KIRKLEES METROPOLITAN COUNCIL INVESTMENT & REGENERATION SERVICE

DELEGATED DECISION TO DETERMINE PLANNING APPLICATIONS

Reference No:	2024/62/91754/E
Site Address:	14, Manor Road, Farnley Tyas, Huddersfield, HD4 6UL
Description:	Erection of single storey rear extension, partial demolition of existing rear wall, door opening to garage (within a Conservation Area)
Recommending Officer:	Edward Cheseldine

DECISION – REFUSED

WEST ELEVATION AS PROPOSED
 Scale 1:100
 Drawing AP/5

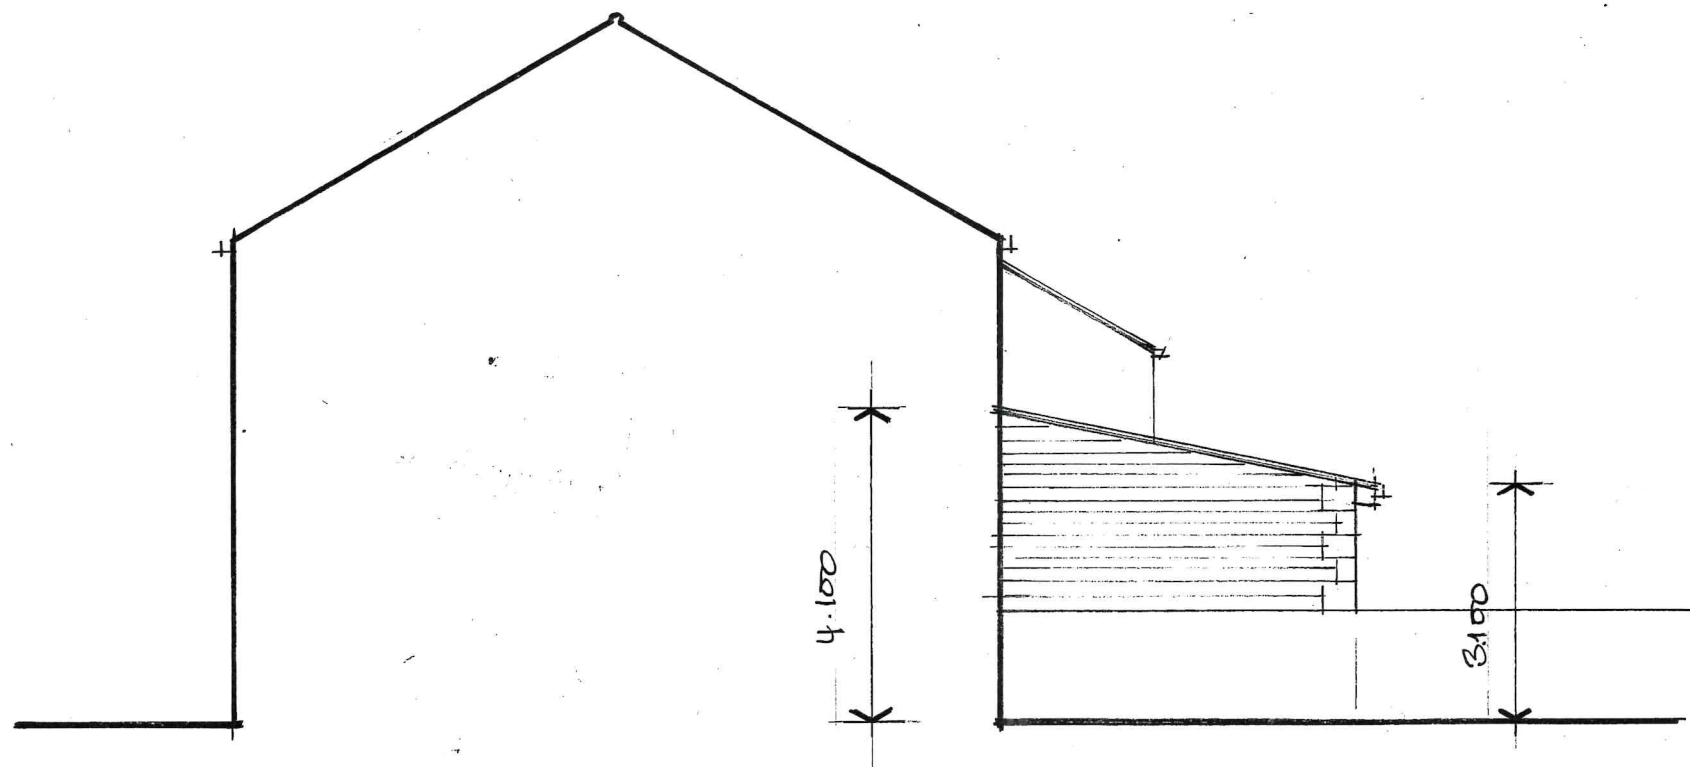
In terms of the extension, it appears highly glazed and a large dominating structure. A significant proportion of the extension runs along the side

The proposed extension has a maximum height of 4.20m, which sits just below the cills of the exterior windows. It spreads across the full width of the building with no separation distance from the adjoining property. The extension projects past the original rear elevation by 4.70m. The building has already been doubled in size in terms of volume due to the two-storey side extension. Considering the span of the rear elevation of the building, the additions should assimilate with the host dwelling to provide a harmonious appearance. However, due to the projection and high roofline, the cumulative impact of the extensions would dominate the original building.

The architectural design of the extension is modern in its approach due to the panels of glazing which accommodate a significant amount of the elevation space. In part, due to its features the extension does not harmoniously assimilate with the host building. Given they are large and appear superfluous on the rear elevation, they would significantly alter the character of the historic dwelling.

In terms of a loss of light, outlook or an overbearing impact, the extension runs along the shared boundary increasing in height from 3.10m-4.10m. The nearest habitable window at 12 Manor Road is 1.50m away, which serves a living room. The relationship is close.

Due to the extension's projection and height, it is considered that the extension will materially affect the amount of light observed in this room, as well as its outlook. The Council's adopted House Extensions and Alterations SPD sets out that a 45° line when taken from the Centre of the Cill should not be cut. Although no specific drawings have been provided in this regard, it is clear this line would be cut, the extensions bulk and proximity to the window is considered to be significant in this case resulting in a detrimental impact within a habitable room.

EXIST ELEVATION AS PROPOSED
 SCALE 1:100
 DRAWING A/P 4

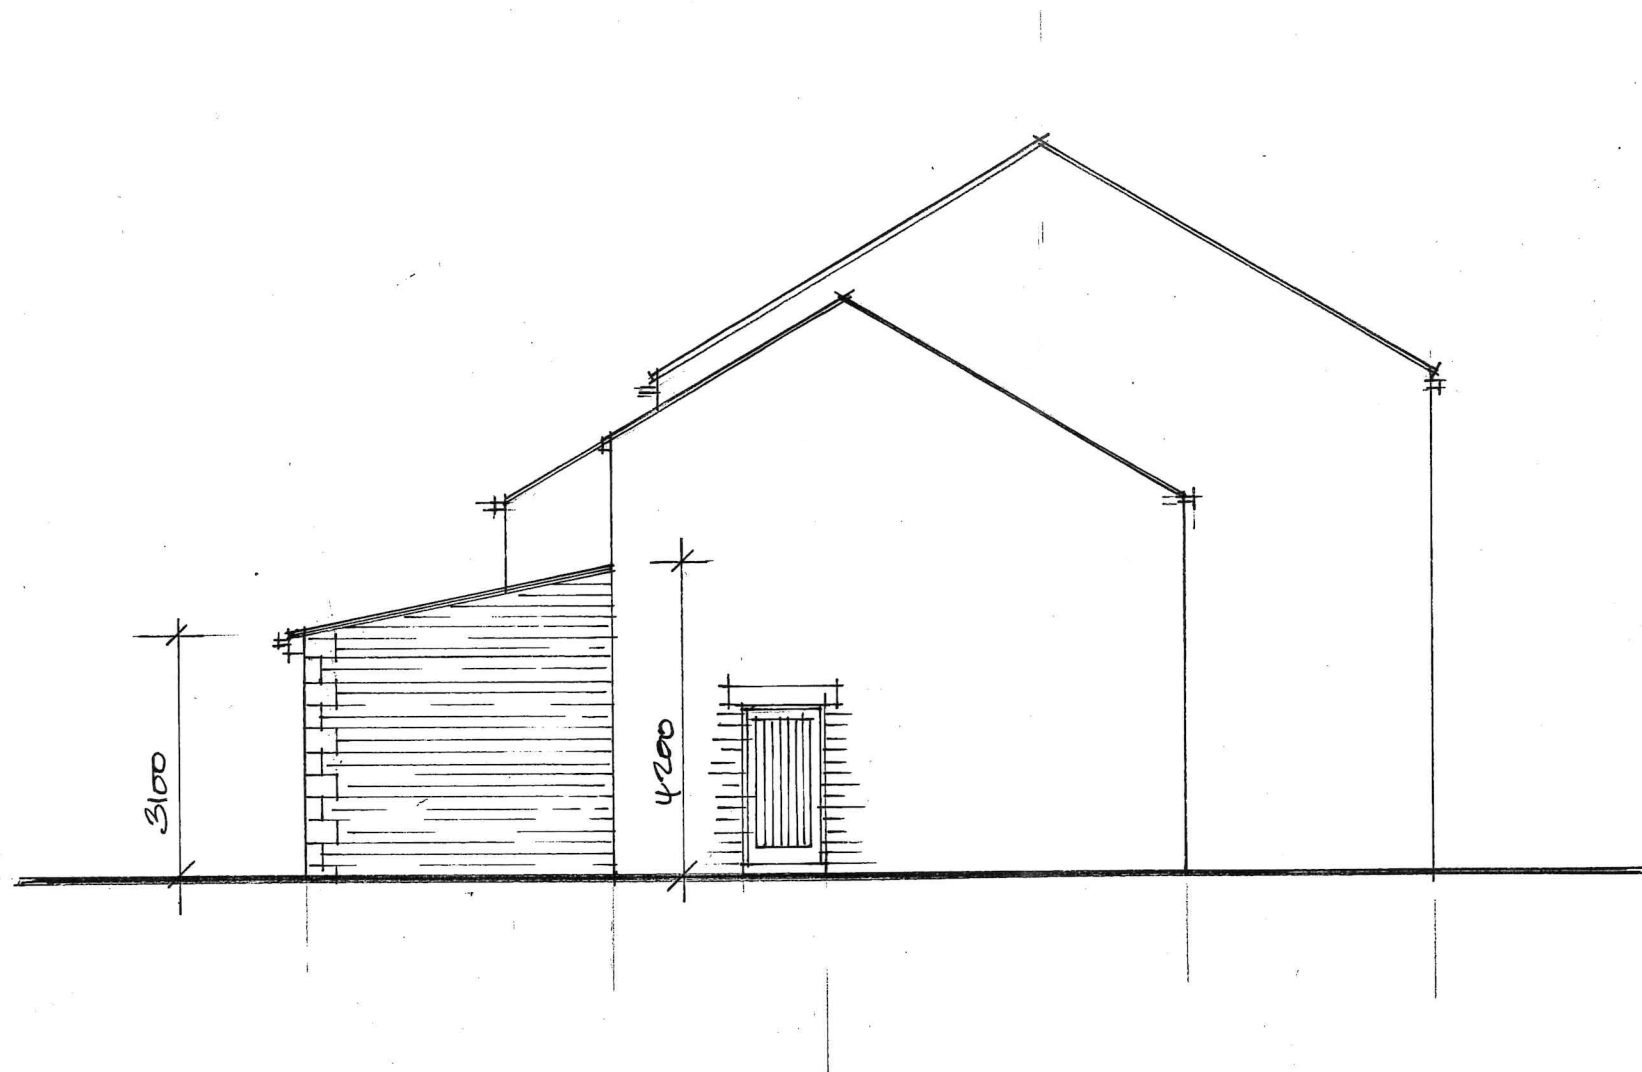
projection which was constructed pursuant to a 2016 application. A pine tree currently screens part of the side elevation of the side extension. Under this application, it is proposed that the tree would be removed. This would reveal the side elevation of the proposed extension. Trees contribute to the setting of conservation areas. This application is not accompanied by arboricultural reports to indicate the maturity and nature of the tree.
